**From:** Cornelis Duba <Cornelis.Duba@endeavourenergy.com.au>  
**Sent:** Tuesday, 1 August 2017 3:09 PM  
**To:** DPE CSE Information Planning Mailbox  
**Cc:** Jennie Saban  
**Subject:** NSW Planning & Environment Notice of Exhibition SSD 8096 Molecular and Life Sciences Building University of Wollongong, Wollongong Campus  
**Attachments:** Endeavour Energy MDI0044 Easements and Property Tenure.pdf; Endeavour Energy FAM 0048 Dispensation Request.pdf; Endeavour Energy Technical Review Request FPJ 6007 July 2017.pdf; work\_near\_underground\_assets\_1419[1].pdf; Safety+clearances\_May+11.pdf; Safety+on+the+job.pdf; FactSheet\_Building\_Construction+web.pdf; FactSheet\_Plumber\_web.pdf

I refer to the Department's letter of 9 June 2017 regarding Development Application SSD 8096 at the Molecular and Life Sciences Building located at University of Wollongong, Wollongong Campus (Lot 1 DP 1188267) for 'Demolition, site clearing and earthworks; construction of a five storey Molecular and Life Sciences Building with a total 6,974 sqm of floorspace; construction of a pedestrian bridge link to the existing Illawarra Health and Medical Research Institute building; and landscaping, service

Figure 2: Snapshot from UoW Easement drawing - easement in the vicinity of proposed site

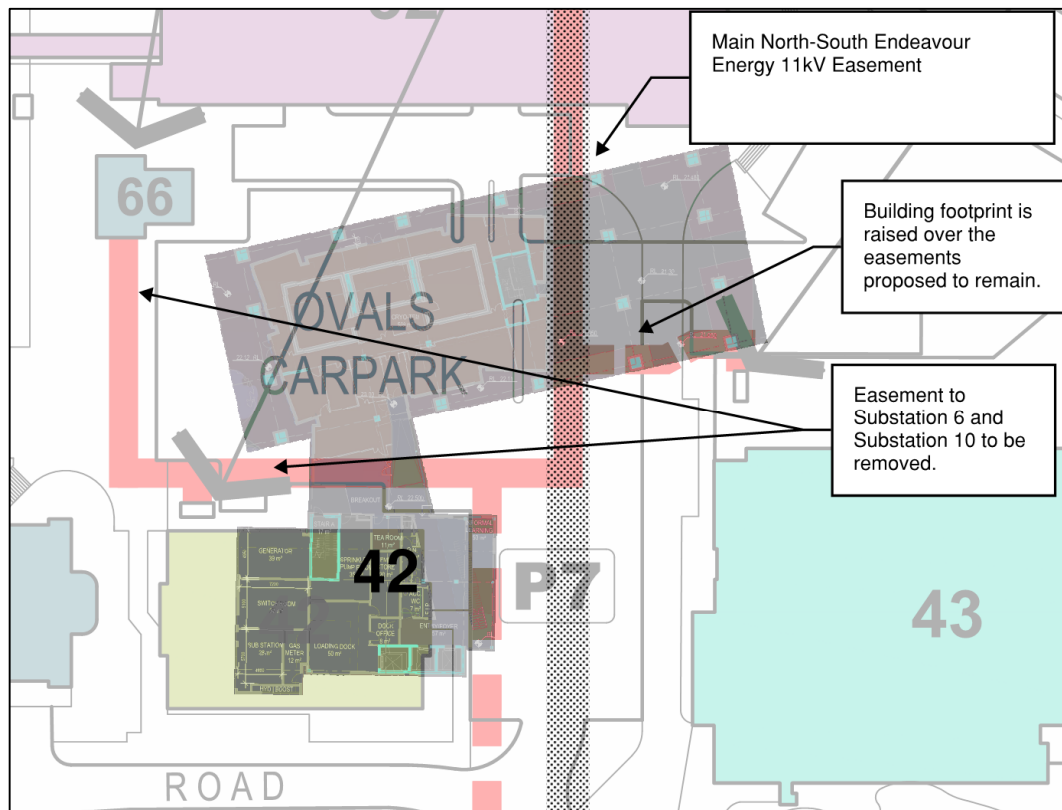
The foregoing is addressed in with the below point 'Network Capacity / Connection'. However the 'Services and Infrastructure Report' indicates as shown in the following extract of 'Figure 2' indicates 'Building footprint is raised over the easements proposed to remain'.

If the applicant can demonstrate that there is no other option but for the 'Building footprint is raised over the easements proposed to remain', then they will need to submit the attached Company Form (Network) FAM 0048 'Dispensation Request'. Failing this, either the cables will need to be relocated or the building footprint altered so that it is not over the easements proposed to remain.
